## **Comment and request for clarification regarding planning applications and Listed Building Consent for Newsome Mills:**

**2019/91404**

**2019/91633**

**2019/91630**

Title
Location Plan

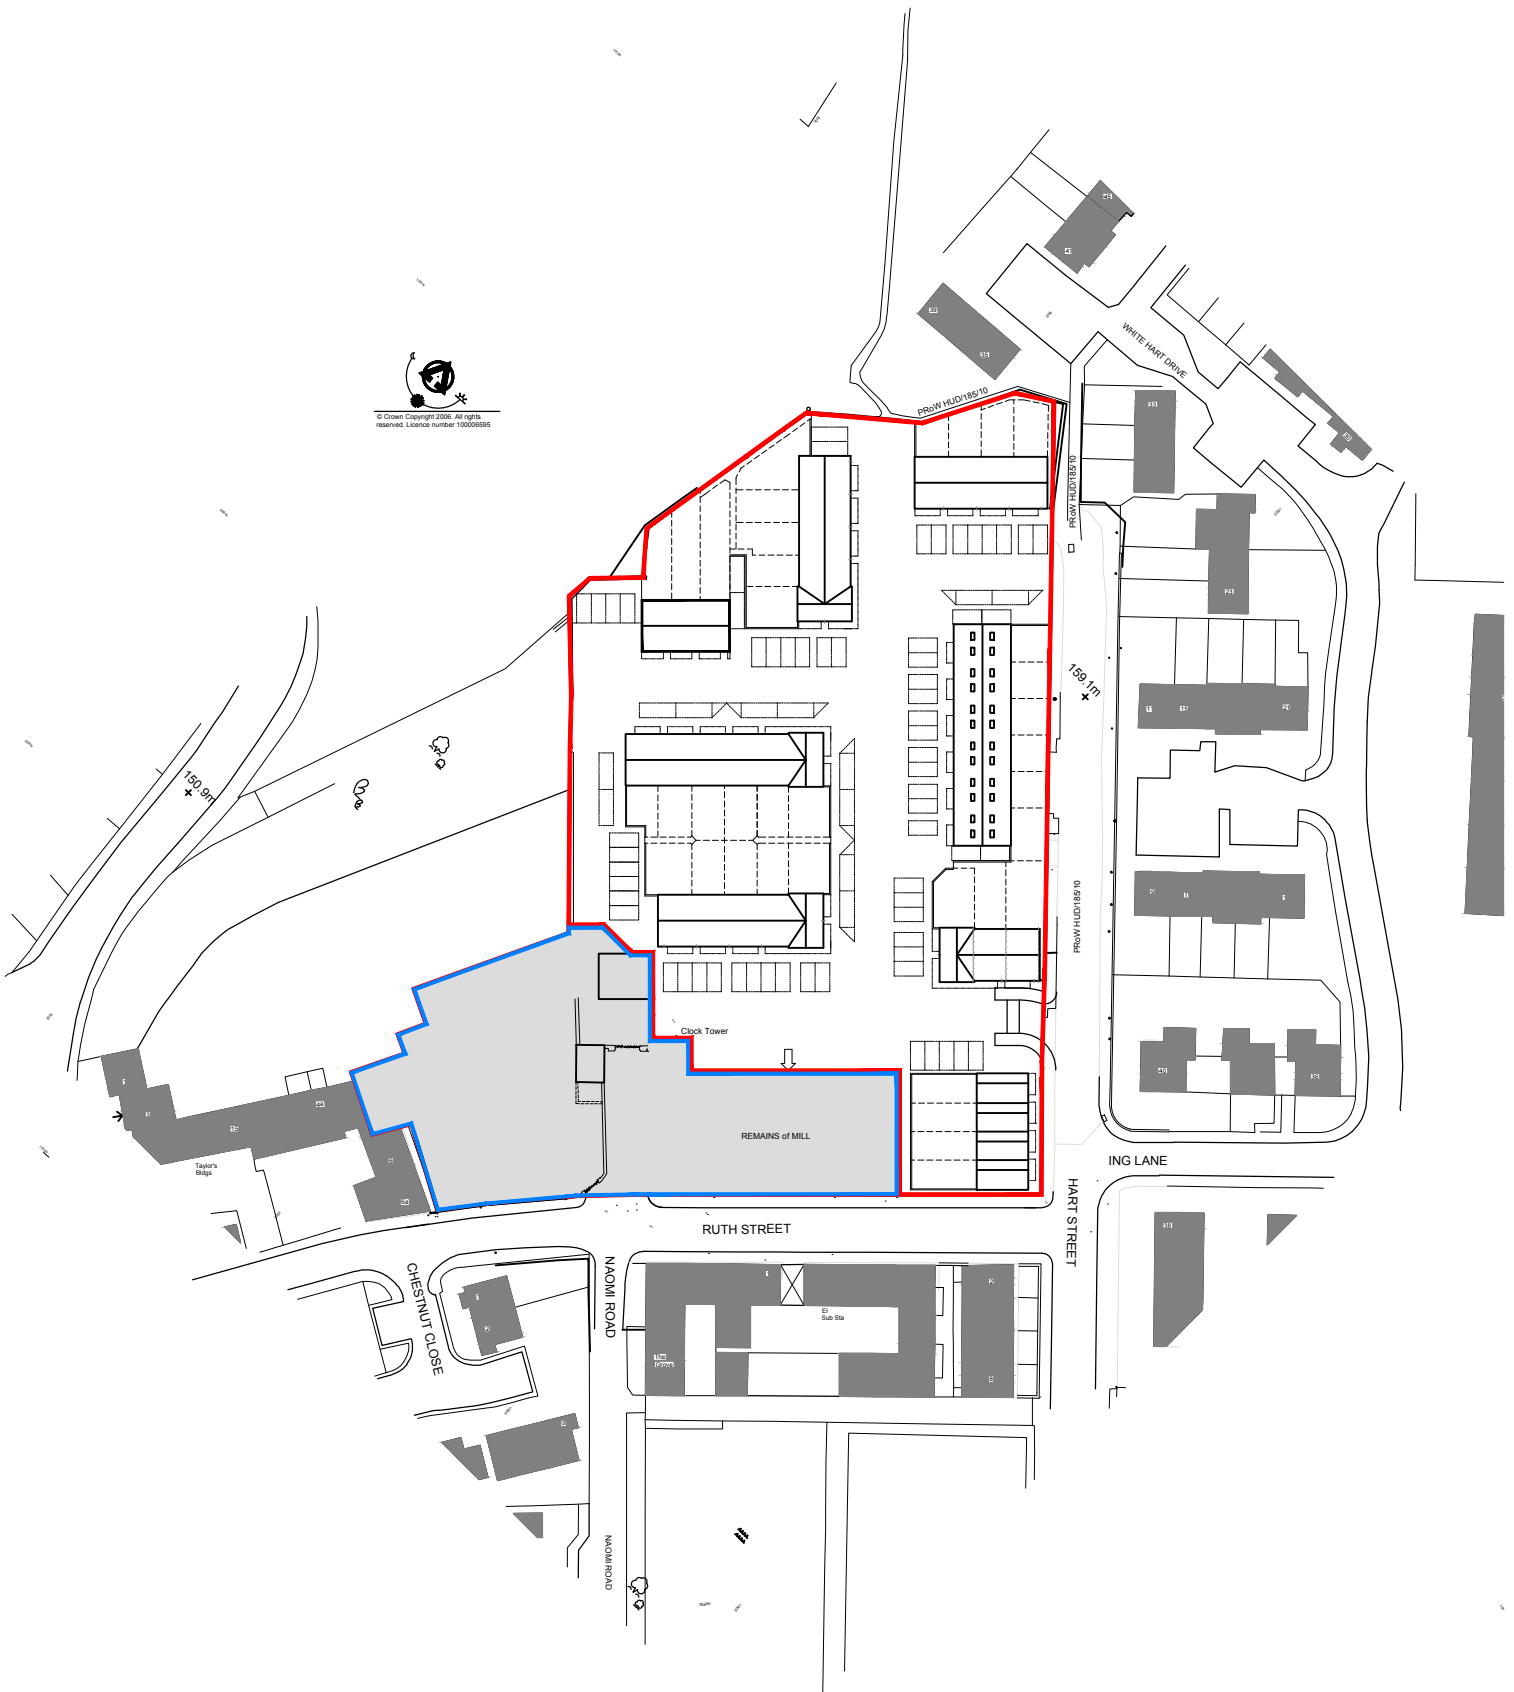
- The former four storey mill, clock tower and weaving sheds are a single building. The building is Grade II Listed.
- The boundary of the Grade II Listed Newsome Mill is incorrectly drawn on the location plans, with the weaving sheds section of this Grade II Listed building being omitted (this part of the building is incorrectly shown as being open land).

I have made specific reference to the application for Listed Building Consent, but the same issues also apply to the two planning applications (**2019/91633 & 2019/91630**). In both of these applications, the boundary of the Grade II Listed building is also incorrectly drawn as omits the weaving sheds.

- Are the plans valid, given that the Grade II Listed Newsome Mill is incorrectly drawn in the plans?
- Will you be making the Strategic Planning Committee aware of the errors in the plans?

- Is it possible to place a condition on planning consent that the plans should be amended to accurately reflect the boundary between the listed structures and the open land at Newsome Mills? We suggest this would require the weaving sheds section of Newsome Mill to be included in planning application number **2019/91633** (alterations to the mill), instead of in planning application number **2019/91630** (new dwellings). Is this possible?
